### Application for Planning Permission

**Development:** Erection of 1 No single storey, self-build dwelling with car parking to include provision of driveway and car parking for No. 16 Swanbourne Road. This application is in CIL Zone 4 and is CIL Liable as a new dwelling  
**Location:** 16 Swanbourne Road Littlehampton BN17 6HS

DRAWING Proposed site layout
SCALE As noted @A2

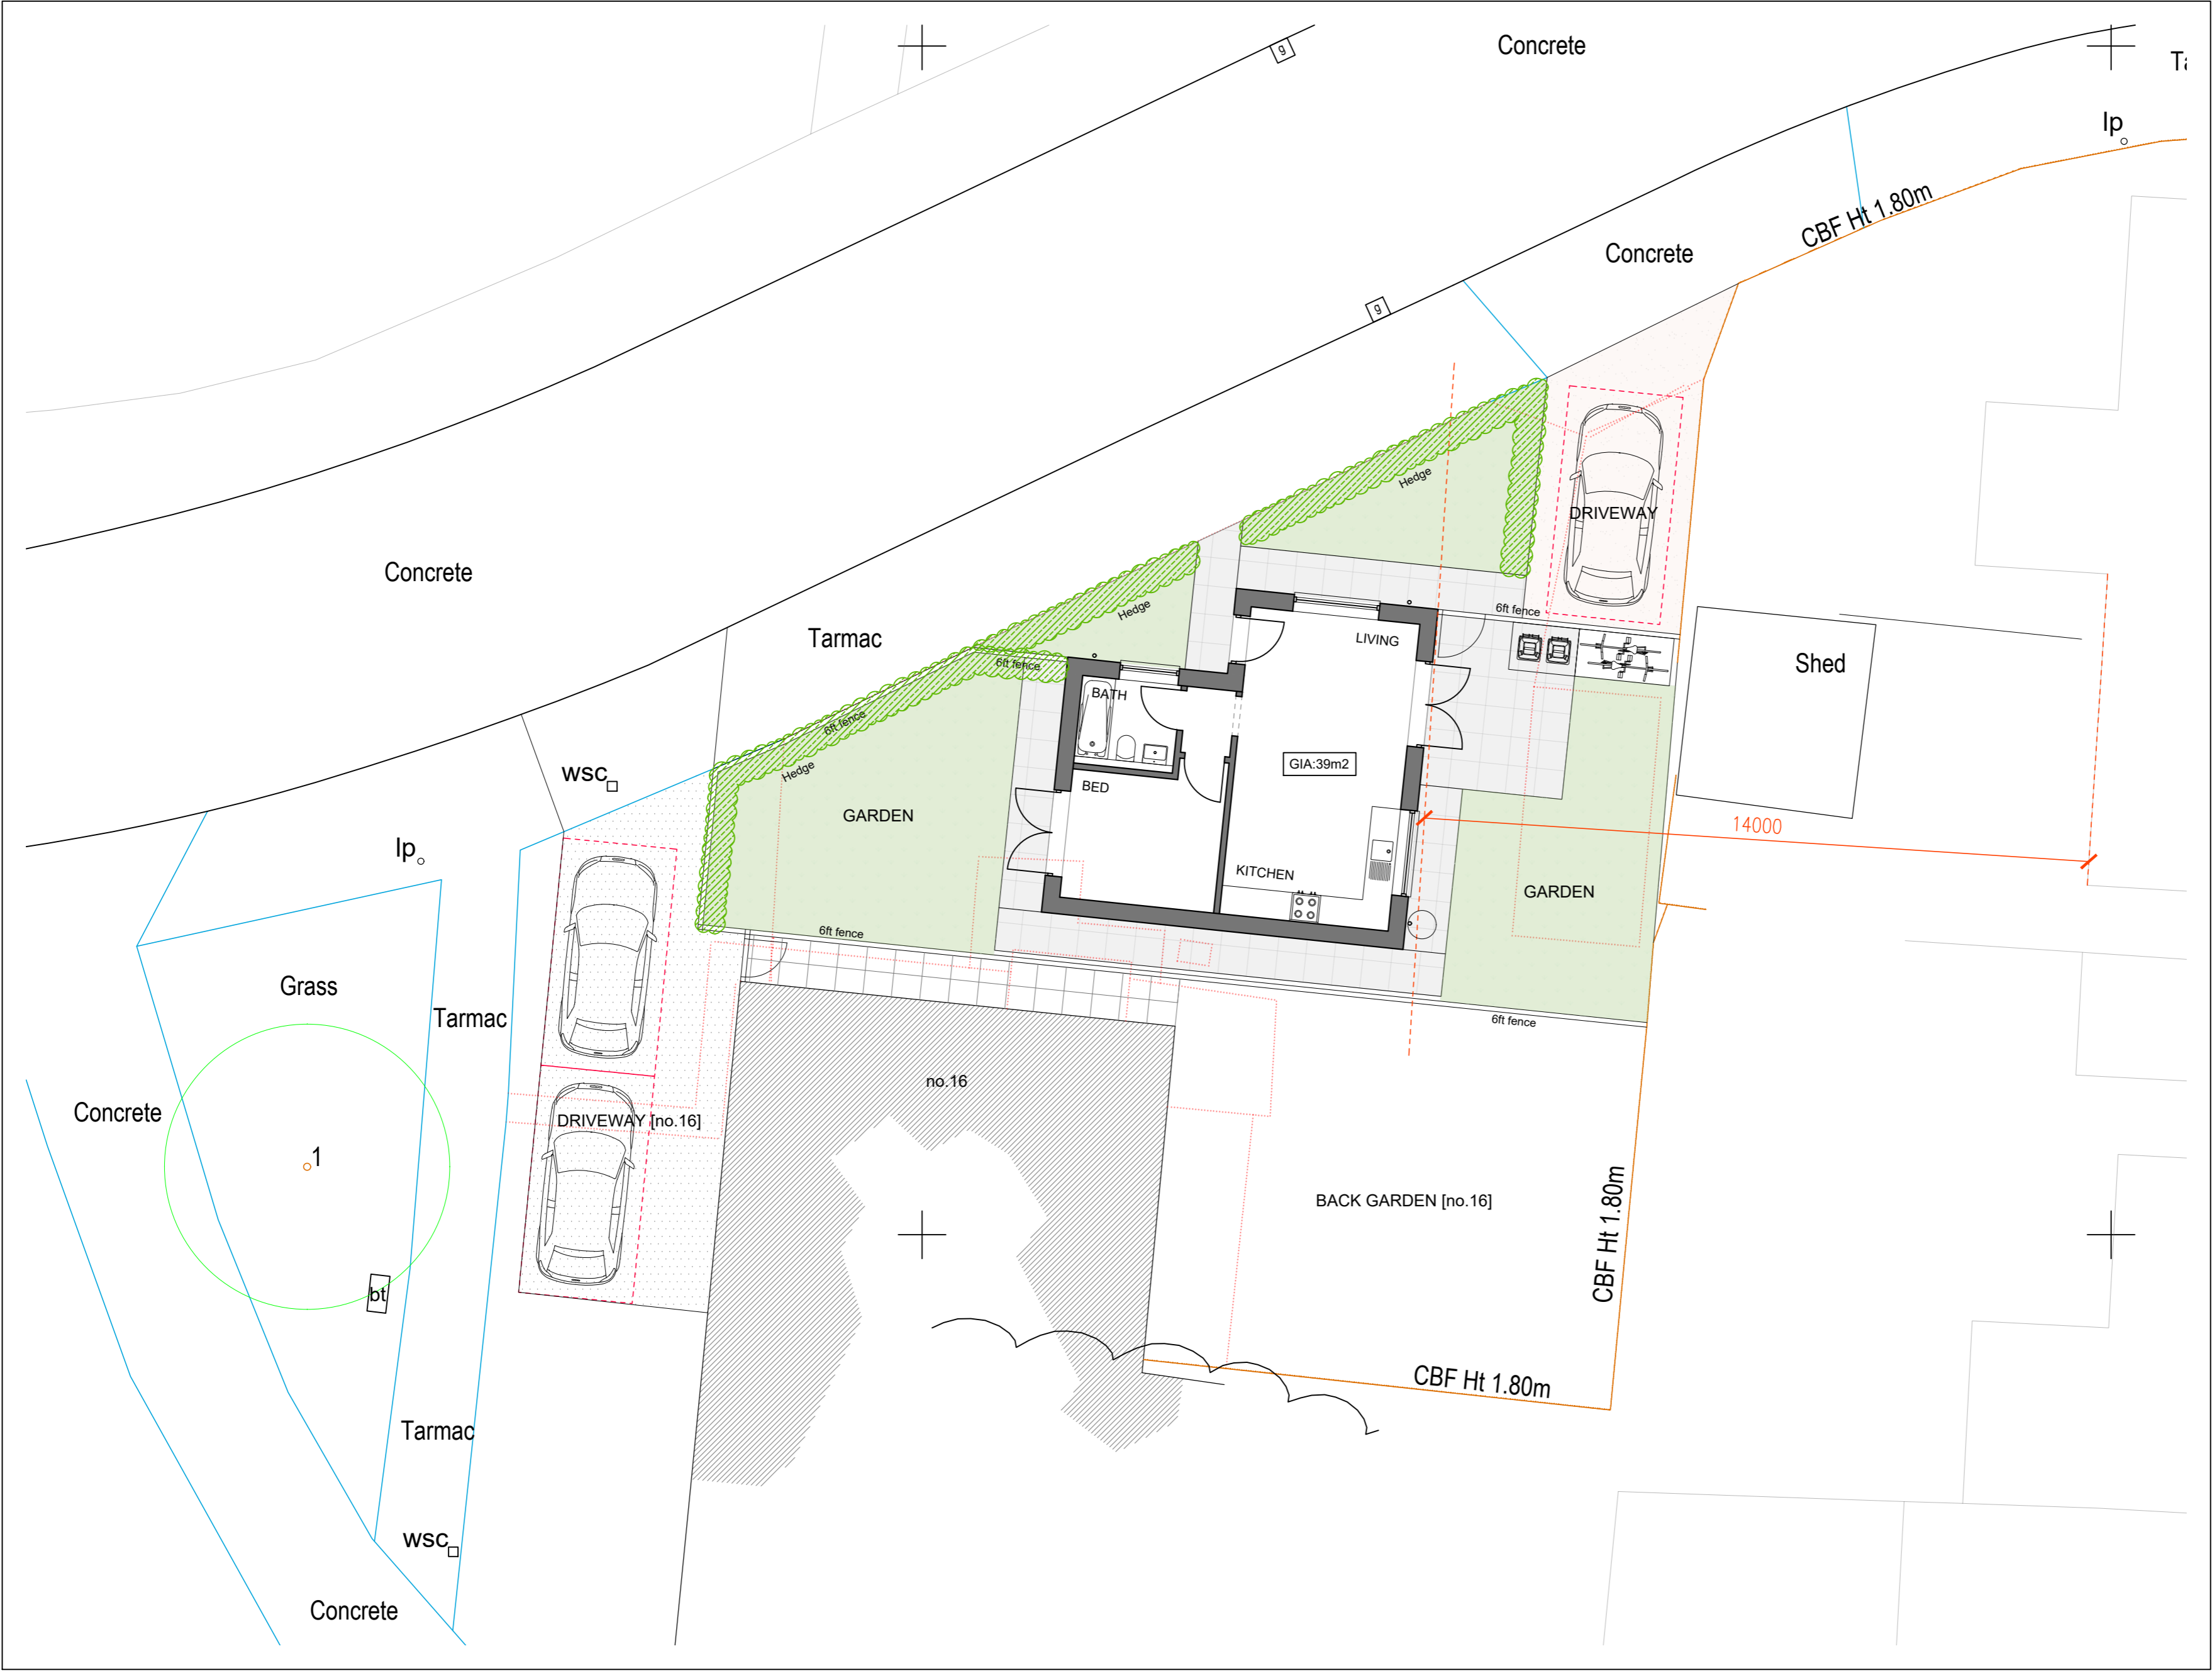
On the proposed site plan, please provide dimensions from the proposal to the site boundaries.
